Subject: RE: RE: P/84/21/DOC Inglenook (Drainage)

From: Simon Davis <Simon.Davis@arun.gov.uk>
Subject: P/84/21/DOC Inglenook (Drainage)
Date: 1 July 2021 at 16:50:03 BST

From: Laura Gibbons <Laura.Gibbons@arun.gov.uk>
Sent: 01 July 2021 15:39
To: Planning.Responses <Planning.Responses@arun.gov.uk>
Cc: Simon Davis <Simon.Davis@arun.gov.uk>
Subject: FW: Planning Consultation on: P/84/21/DOC

Condition 6- surface water drainage design

Drawing Status	FOR APPROVAL						
Client	Future Group Development Ltd						
Project	Land at The Inglenook Pagham Road, Bognor Regis PO21 3QB						
Drawing Title	Proposed Drainage Arrangement Sheet 2 of 2						
Scale	1:200	Date	May 2021	Drawn By	DJL	Checked By	MJA
Drawing No.	D1966-103.2	Rev.	-

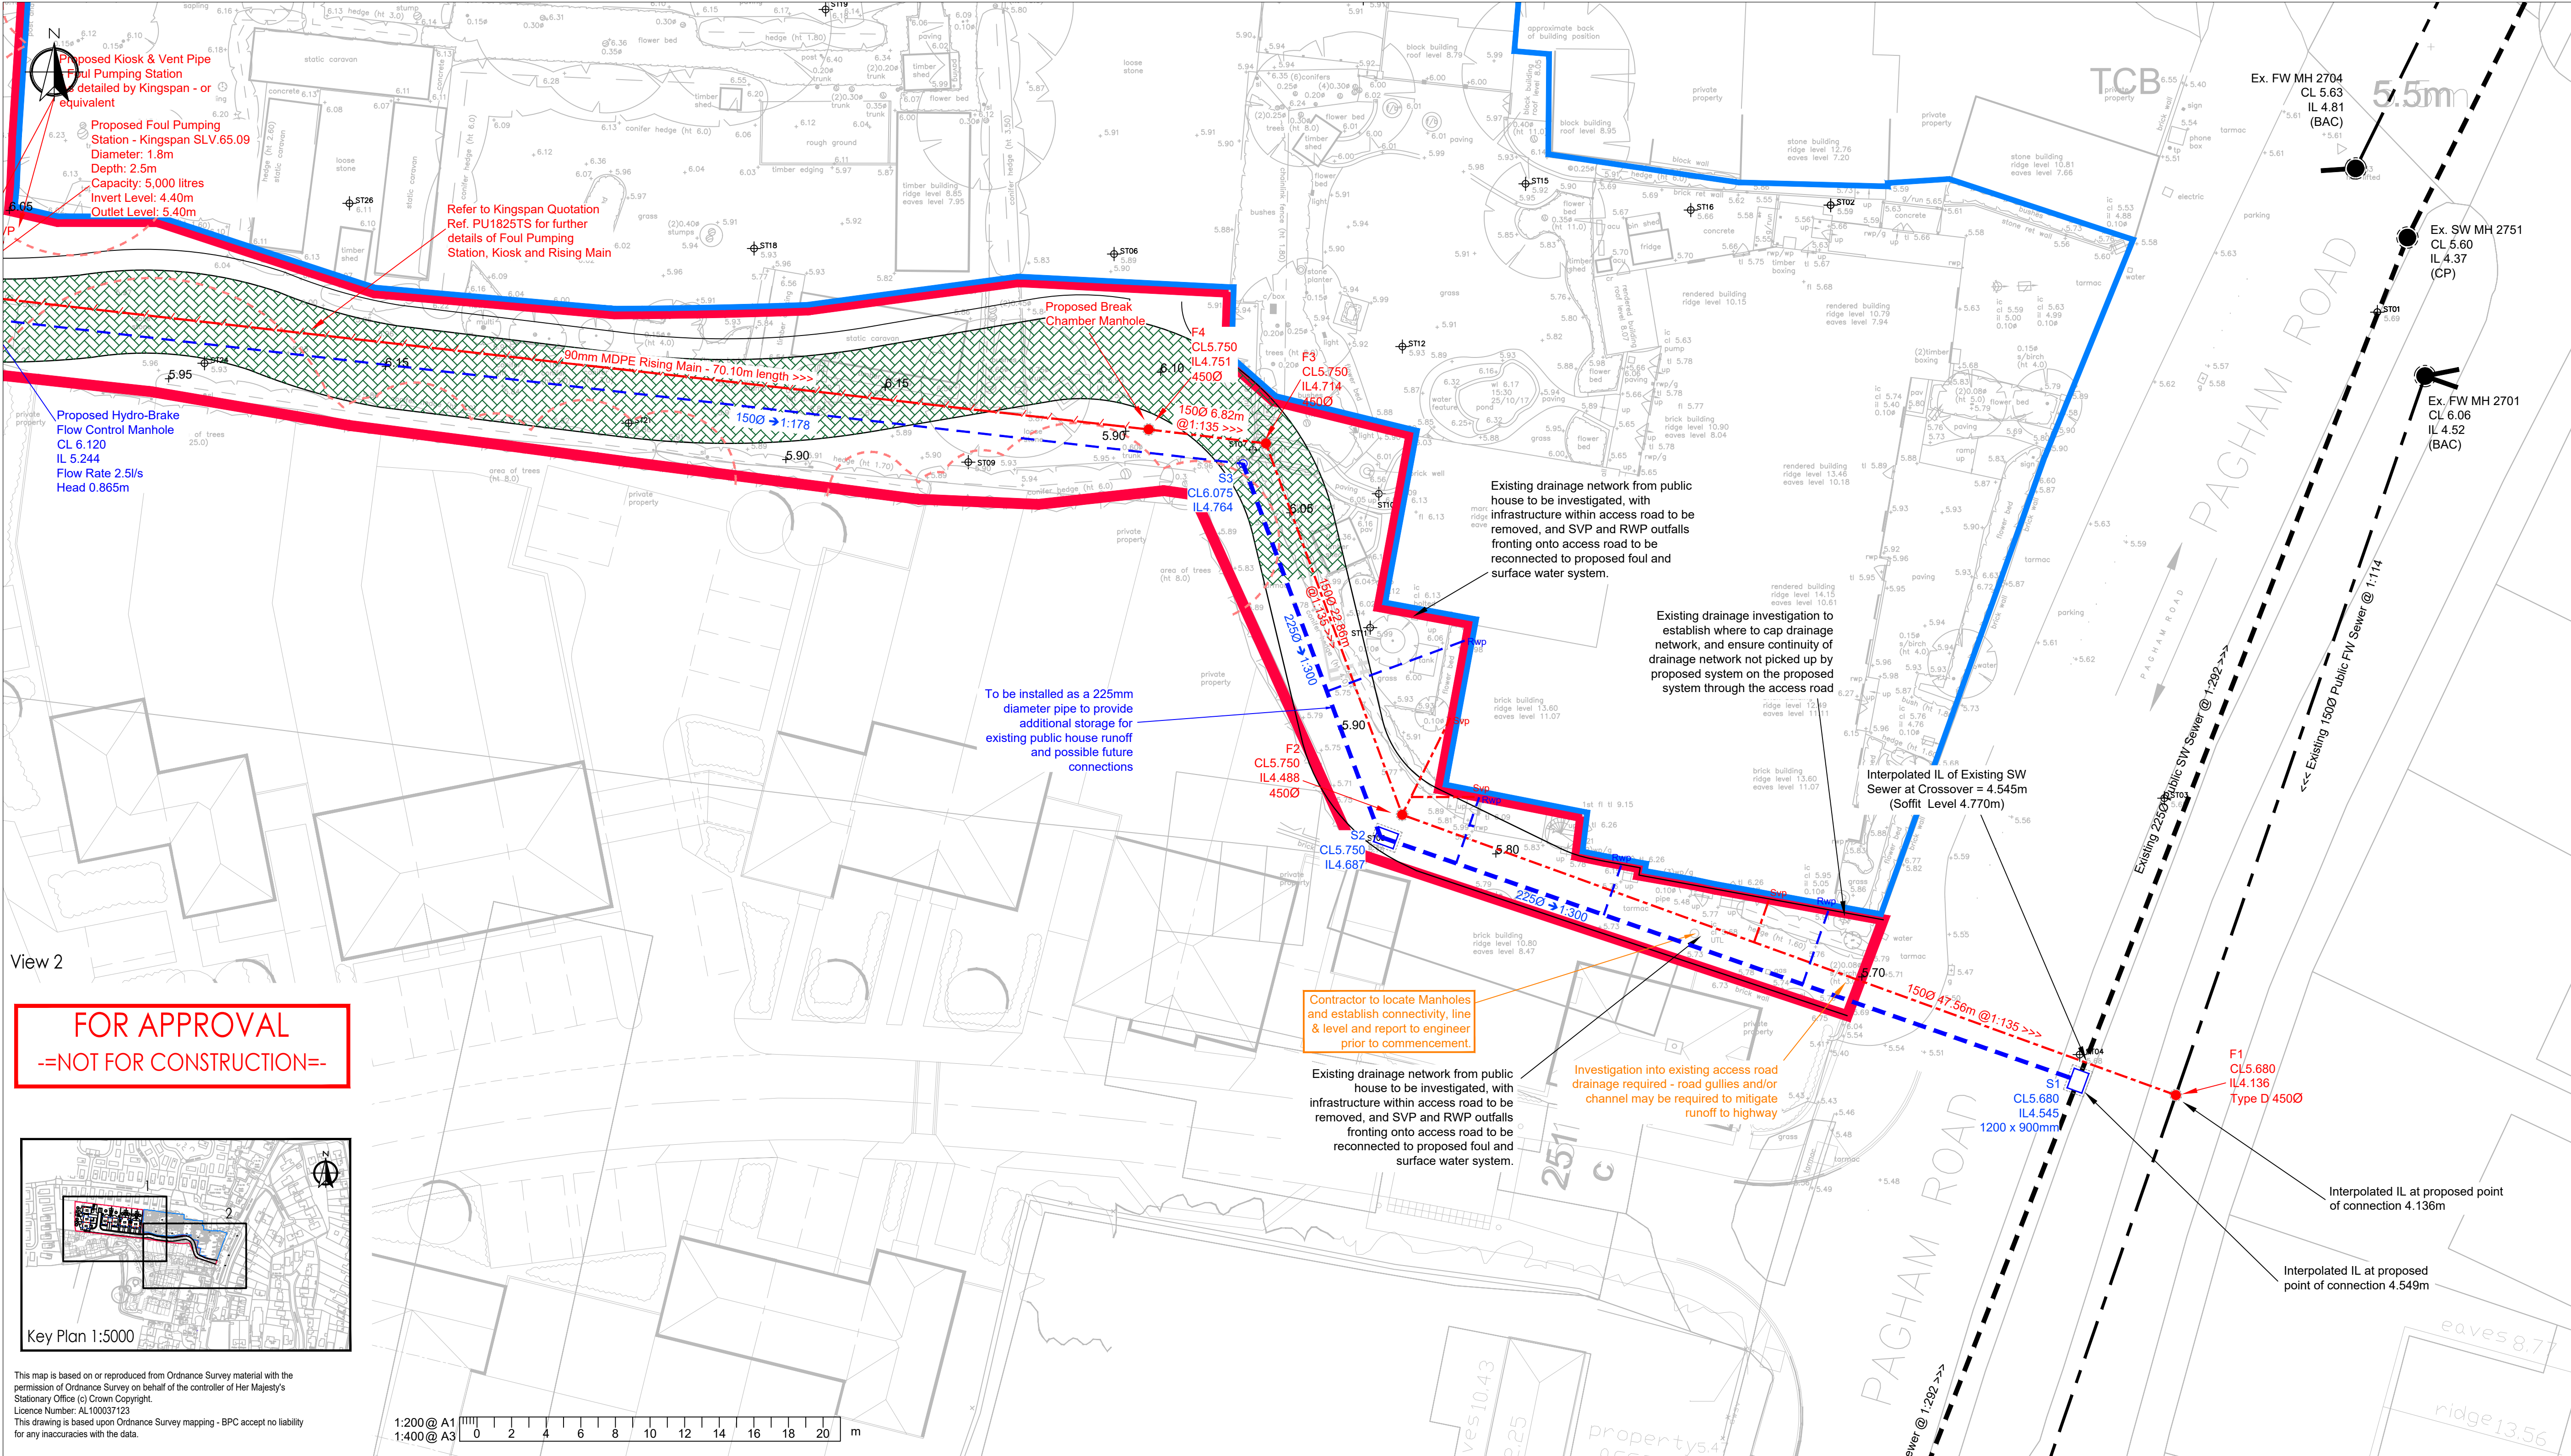
1. Please can the applicant submit a catchment area plan
2. Please can the applicant submit greenfield runoff calculations
3. Please can the applicant submit winter groundwater and infiltration testing here. We have had previous discussions directly with the applicant's consultant, but the testing/ monitoring information should be submitted with this application.
4. Please detail formation level of permeable paving on plans.
5. Please state hydrobrake reference on both layout and construction detail.
6. Please show hydrobrake bypass door, operating rope and fixing and construction detail.
7. Please confirm if lowest invert of sub-base and correct slope are modelled correctly in calculations.
8. Please supply evidence of southern waters acceptance of proposals. E.g. S106 approval and capacity check.

We cannot recommend discharge of this condition until the drainage design has been agreed.

Re. our conversation, I can confirm we are able to provide the additional clarification without issue for points 1-7 from Laura/Simon below but we are unfortunately still waiting on Southern Water's S106 approval (point 8).

The chase to Southern Water and confirmation of payment receipt from them means that we now are in a 21 day waiting period for the technical response. Given this may result in minor technical amendments to the drainage strategy to obtain Southern Water's approval also, it makes sense to request an extension of time from ADC for Condition 6/7 pending this approval.
